Eastern Creek REP Throughput Increase (SSD 11606719)

Department's comments on Environmental Impact Statement

25 August 2022

Figure 2.1

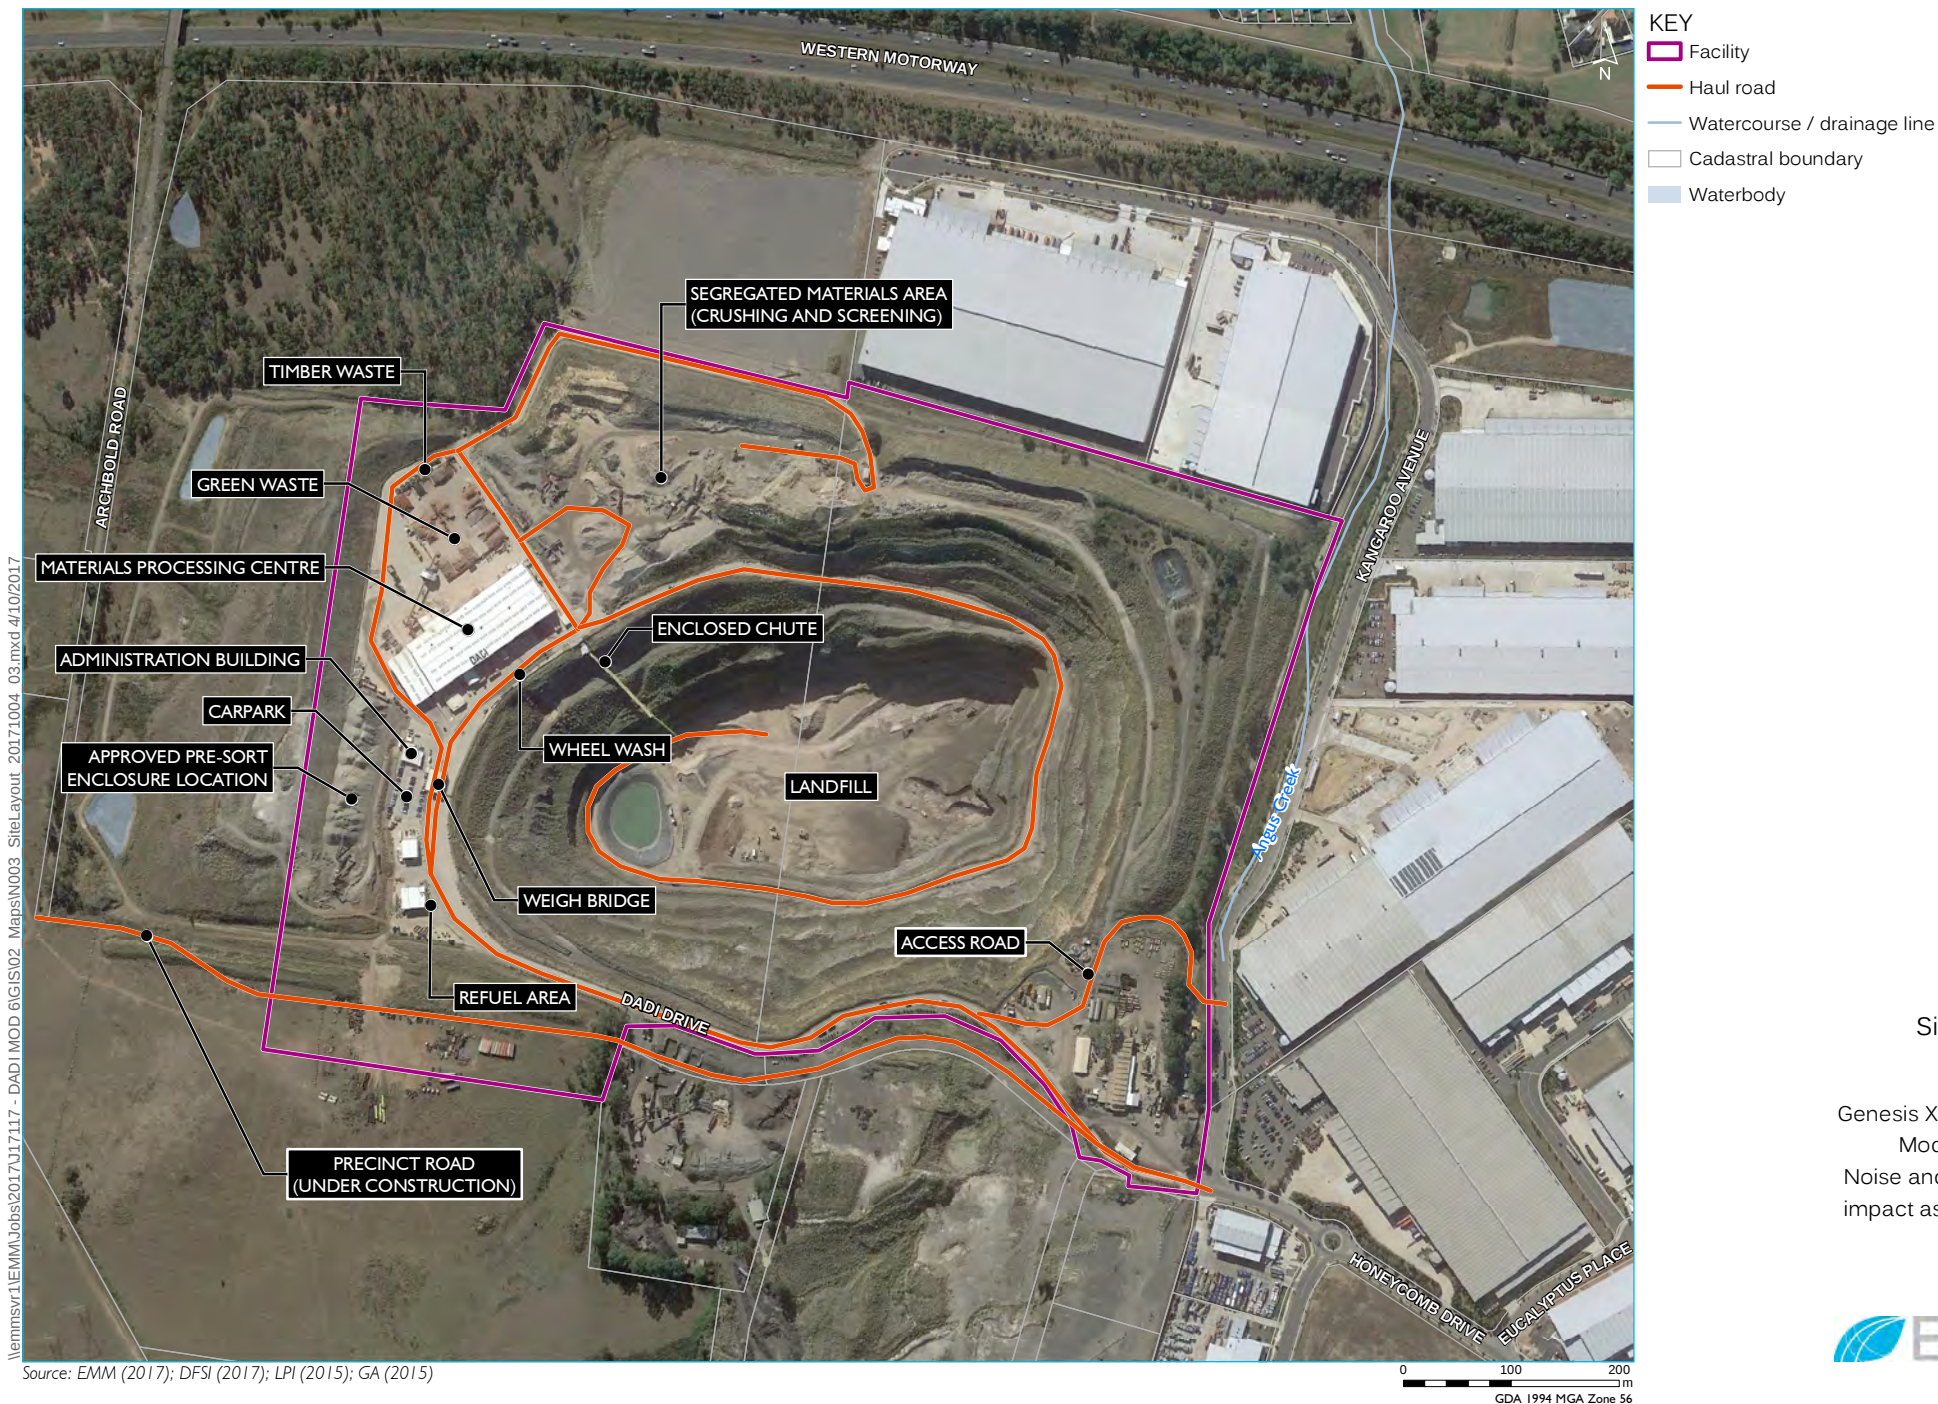
- The assessment locations provided in the Noise and Vibration Impact Assessment (NVIA) in Figure 2-1 appear to be located on the southern Minchinbury residential boundary closest to the site and near the M4 Motorway. The Department notes the EPA's Noise Policy for Industry (NPfI) requires an assessment to be undertaken at the most-affected locations, rather than simply the closest ones. A most-affected location is a sensitive receiver location that experiences (or will experience) the greatest noise impact from the noise source under consideration. Please provide justification and demonstrate that the NVIA has considered all representative receiver locations which are most affected by the Proposal.
